RE: 261 Danforth St
CBL: 057- - B-022-001-01
DU: 3

NOTICE OF VIOLATION

DATE: 24 NOV. 98 ADDRESS: 261 Danforth ST. CBL 057 B-022
REASON FOR PERMIT: Replace Fire Escape
BUILDING OWNER: Brad Morrison
CONTRACTOR: RENT-A-Husband
PERMIT APPLICANT: ↑
USE GROUP R-2 BOCA 1996 CONSTRUCTION TYPE SB

# Ballast Sectional

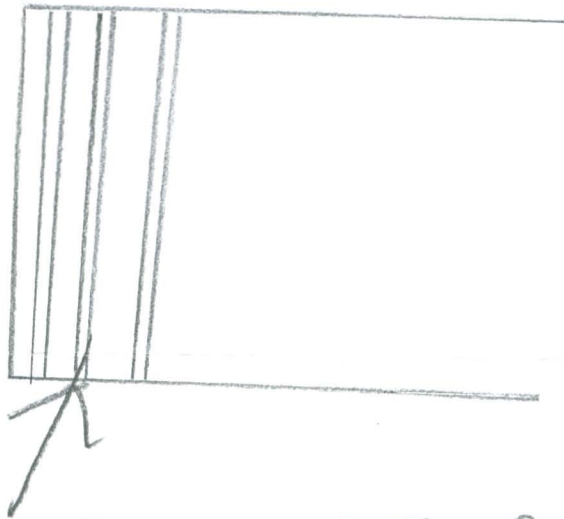
7. Sound transmission control in residential building shall be done in accordance with Chapter 12 section 1214.0 of the city's building code.
8. Guardrails & Handrails: A guardrail system is a system of building components located near the open sides of elevated walking surfaces for the purpose of minimizing the possibility of an accidental fall from the walking surface to the lower level. Minimum height all Use Groups 42", except Use Group R which is 36". In occupancies in Use Group A, B, H-4, I-1, I-2 M and R and public garages and open parking structures, open guards shall have balusters or be of solid material such that a sphere with a diameter of 4" cannot pass through any opening. Guards shall not have an ornamental pattern that would provide a ladder effect. (Handrails shall be a minimum of 34" but not more than 38". Use Group R-3 shall not be less than 30", but not more than 38".) Handrail grip size shall have a circular cross section with an outside diameter of at least 1 1/4" and not greater than 2". (Sections 1021 & 1022.0) - Handrails shall be on both sides of stairway. (Section 1014.7)

* 32. IF This is an exterior Stairway IT MUST meet The requirements of Section 1014.12 of The bldg. code
